PLANNING CONSULTATION RESPONSE

Application No	<u>2026/0342</u>
Proposal	Amalgamation of two semi-detached properties to create a single dwellinghouse, with front gable extensions and dormer window; and associated alterations.
Address	2 St John's Close, Dodworth , Barnsley, S75 3RY
Date of Consultation Reply	14/08/26
Consultee	Highways Development Control

Proposed Site Plan
Scale 1:200

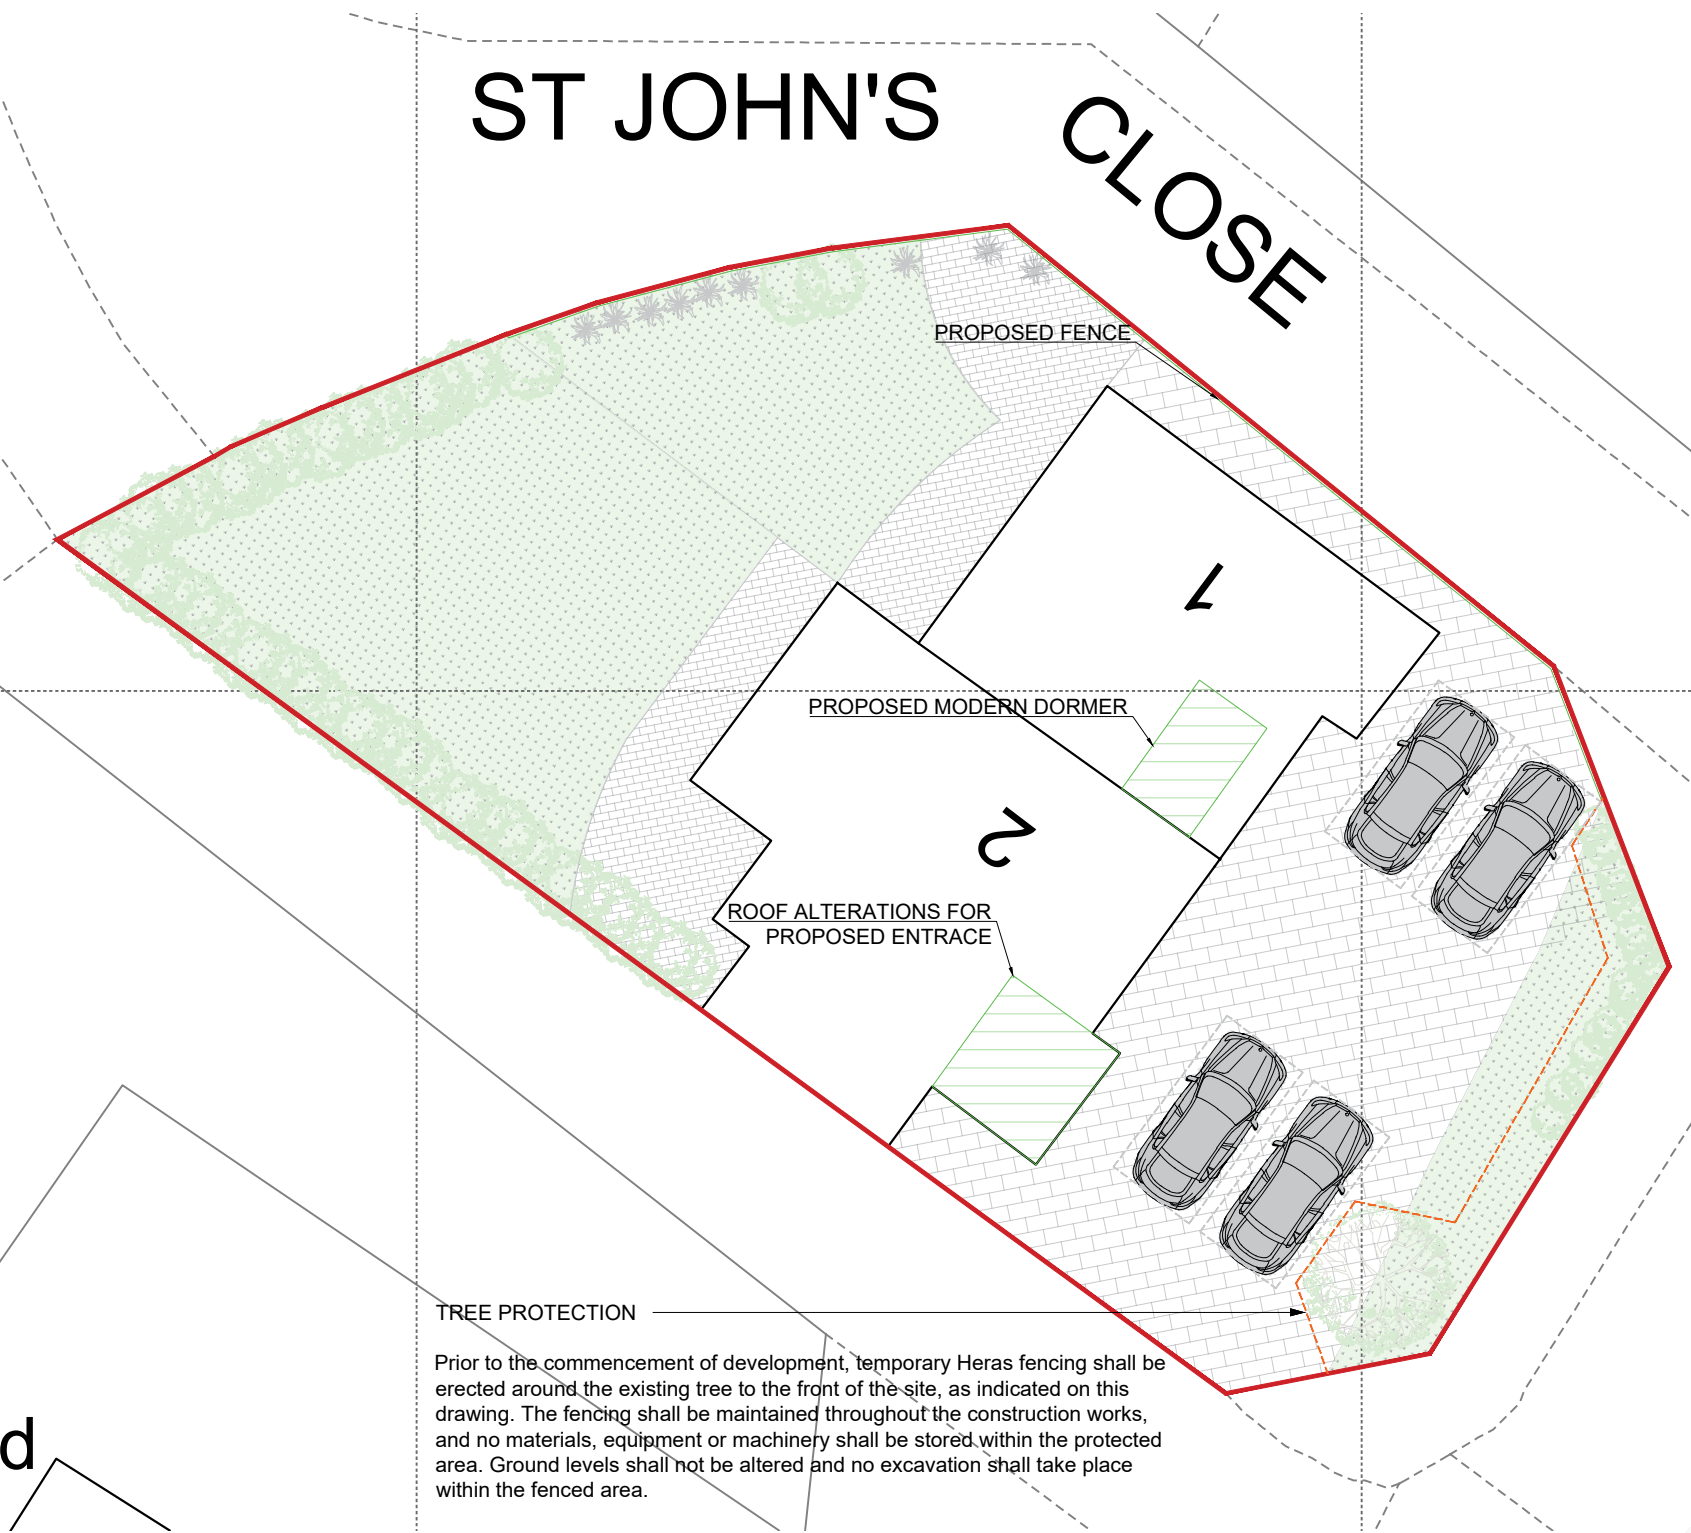
Further to the amended site plan provided by the applicant, it has now been demonstrated that they propose an open frontage which can accommodate up to 4 vehicles utilising the existing access, which is not dissimilar to how parking is currently arranged for one of the properties.

Taking the above into consideration, there are no objections to the proposal from a highways point of view subject to the condition included below.

Before the development is brought into use, that part of the site to be used by vehicles shall be surfaced in a bound, solid material and adequate measures shall be so designed into the proposed access to avoid the discharge of surface water from the site on to the highway.
Reason: To ensure adequate provision for the disposal of surface water and to prevent mud/debris from being deposited on the public highway and to prevent the migration of loose material on to the public highway to the detriment of road safety.
